Comments on Green Hill Solar Farm ENO010170

## RESPONSE TO APPLICANT'S RESPONSES TO WRITTEN REPRESENTATIONS AT DEADLINE 1 : HYD-003 – LAVENDON

Title:
Figure 8.1.5 Site Locations and Study Area
Green Hill G

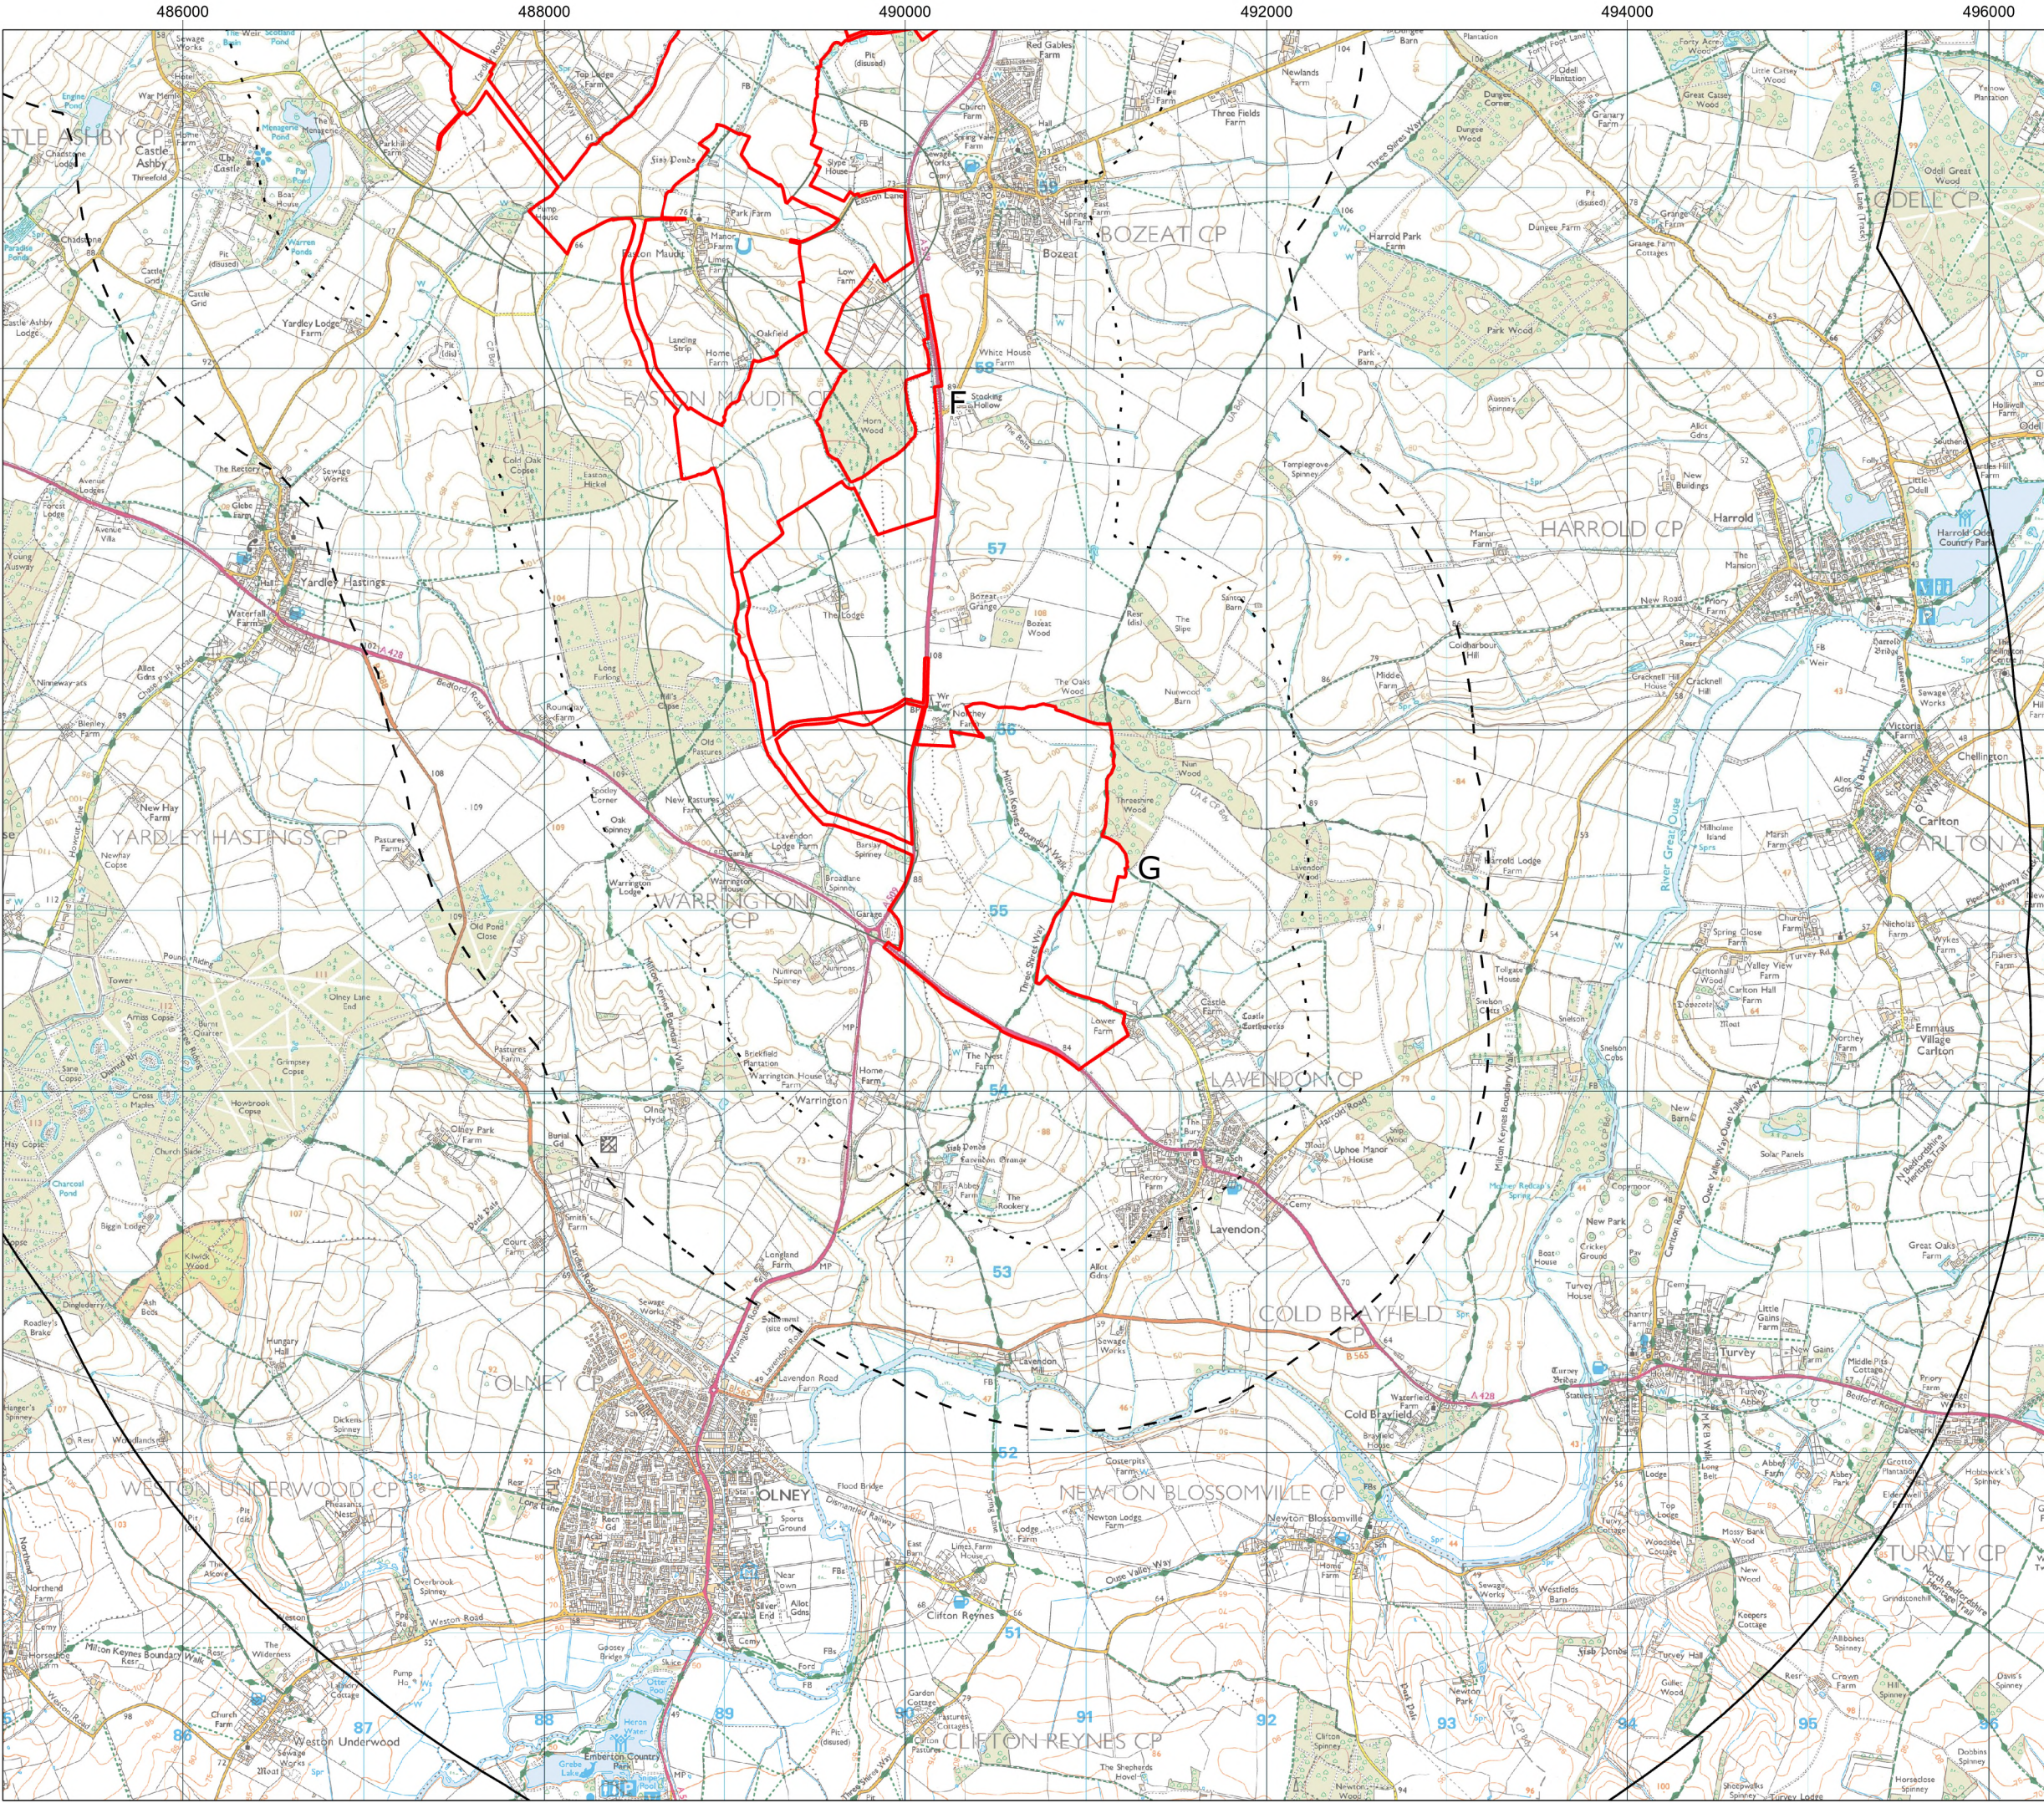
Clause 10.6.88 : According to the EA’s updated Flood Map for Planning, the entirety of Green Hill G is situated in Flood Zone 1 with the exception of a limited area within Field GF13 which is identified as being in Flood Zone 3 (*please reference <sup>[10]</sup>*), associated with a land drainage ditch and unnamed Ordinary Watercourse. However, these extents remain outside of any areas of proposed development (*please reference <sup>[5]</sup>*). The EA Historical Flood Map indicates that Green Hill G has not historically flooded and neither has the area nearby.

The developer states that the “entirety of Green Hill G ... with the exception of the area within Field GF13...”. As the developer has continuously used the exception to their advantage through their FRA and relied on the bigger picture for their assessments, this by no means relieves them of their responsibility to address all areas that do indeed fall into the area of proposed development – especially by their own admission. The comment that “these extents remain outside of any areas of proposed development” appear to be in complete contradiction and disregard of MK’s policy referenced in <sup>[5]</sup>, <sup>[6]</sup>, <sup>[7]</sup> and <sup>[8]</sup>. The Developer cannot simply cherry-pick extractions to their advantage – they are bound by the entirety of policies.

The developer's attention is drawn to the Surface Water Flood Risk comments as well as the surface water flow paths. **Three of the surface water flow paths run through sites G-9 and G-13.**
